TII ref. TII24-126615

Re: Strategic Infrastructure Development – Further Information Submitted in relation to Proposed no. 8 wind turbines and associated works at Laurclavagh and adjacent townlands, Co. Galway

ACP Case ref. PA07.319307

The Authority acknowledges receipt of referral of Further Information in relation to the above Strategic Infrastructure Development application on behalf of Laurclavagh Limited and provides the following observations for the Commissions consideration;

Figure 1c – Existing layout of N83 / L-61461 / L-6146 junction – available visibility splays

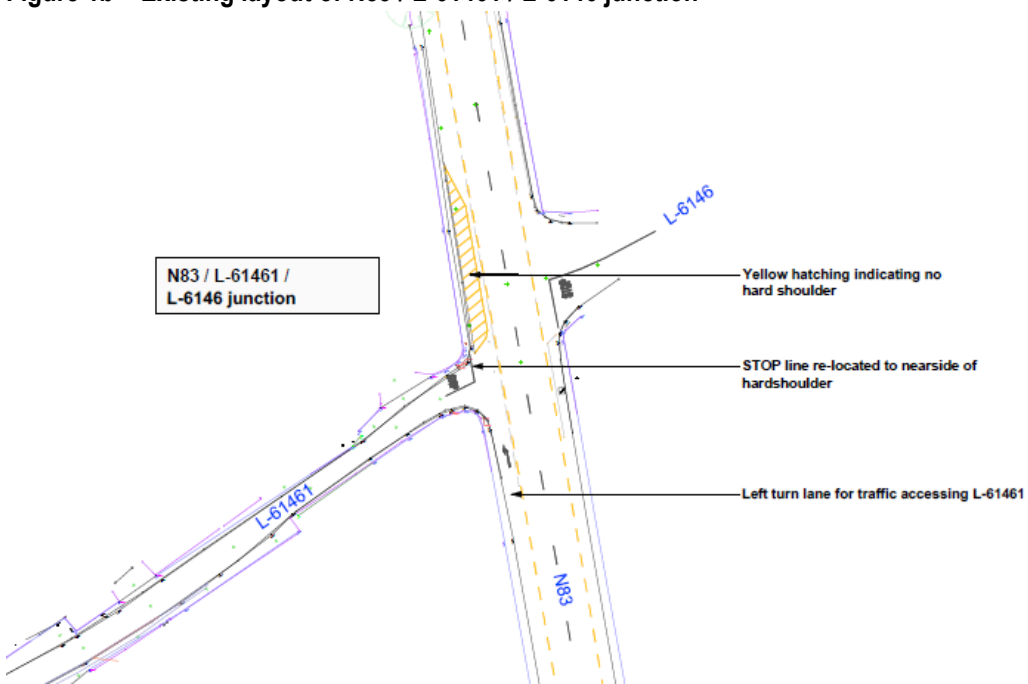
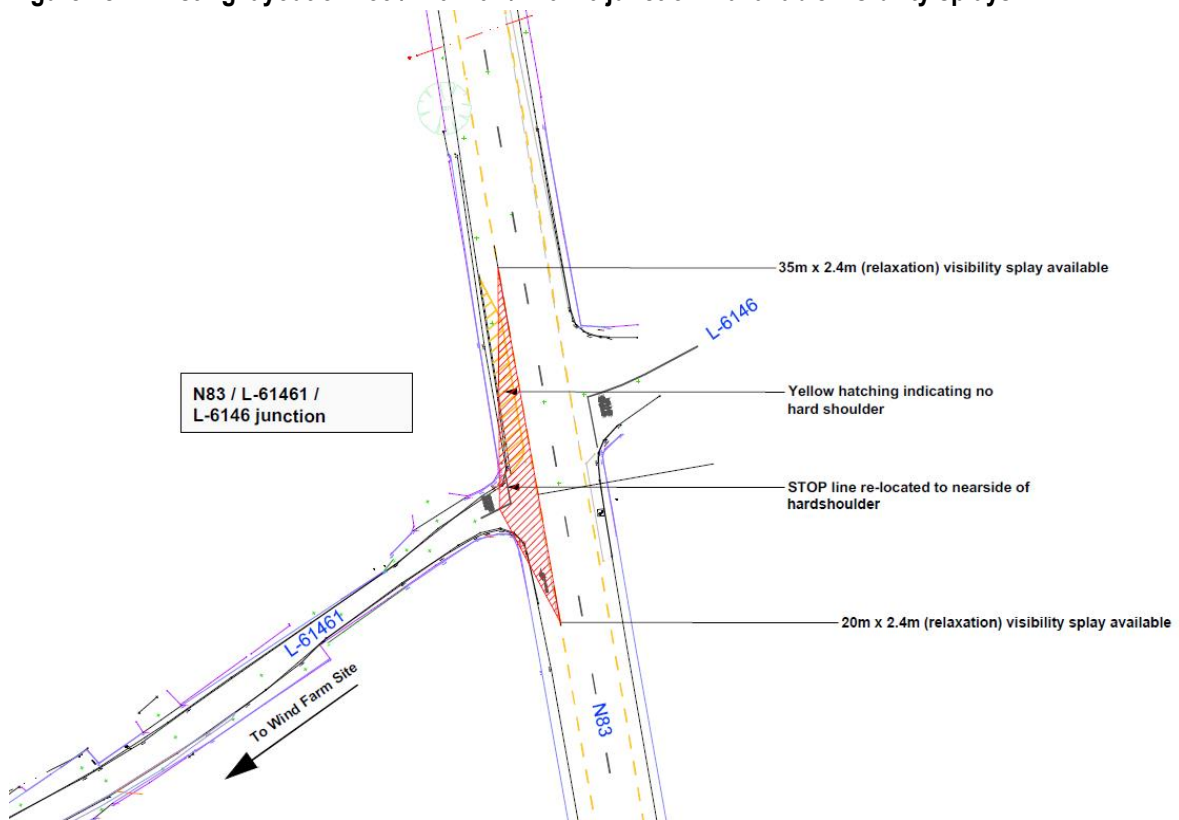
The applicant outlines that the initial lining arrangement that pertained at the time the subject application was first submitted had the stop line located adjacent to the carriageway edge and this provided for full 3m x 215m visibility splays. Reference is made to TII Publications DN-GEO-03060 in that regard.

It is further outlined that the current configuration of the road markings on the L61461 approach to the N83, which is in place at present (August 2025), sets the stop line at the nearside edge of the hard shoulder and has been implemented without any alterations to the boundary walls running parallel to the N83, and as a result, there are significant restrictions to the visibility splays for drivers accessing the N83 from the L61461.

In relation to this matter, it should be noted that the visibility splay / sightlines do not change when you move a stop line. Clause 5.6.2.2 of TII Publications DN-GEO-03060 (Geometric Design of Junctions) requires that the x-distance is measured from the nearside edge of the paved surface (including hard strip or hard shoulder), often referred to as the metalled edge of the road, irrespective of where any stop line may be lined. As such there has been no change to the visibility at this junction. The stop line has been moved and re-lined in accordance with the TII Standard and the Traffic Signs Manual.

Having regard to the foregoing, TII advises that it is critical that where increased traffic from the L61461 local road accesses the N83, national road, arises as a result of the proposed development that sufficient visibility is provided at the local road access to the N83, in the interests of the safety of all road users, and that appropriate mitigation or management of the operation of the junction is provided to the satisfaction of Galway County Council as road authority. TII recommends resolution of this matter prior to any decision on the subject application.
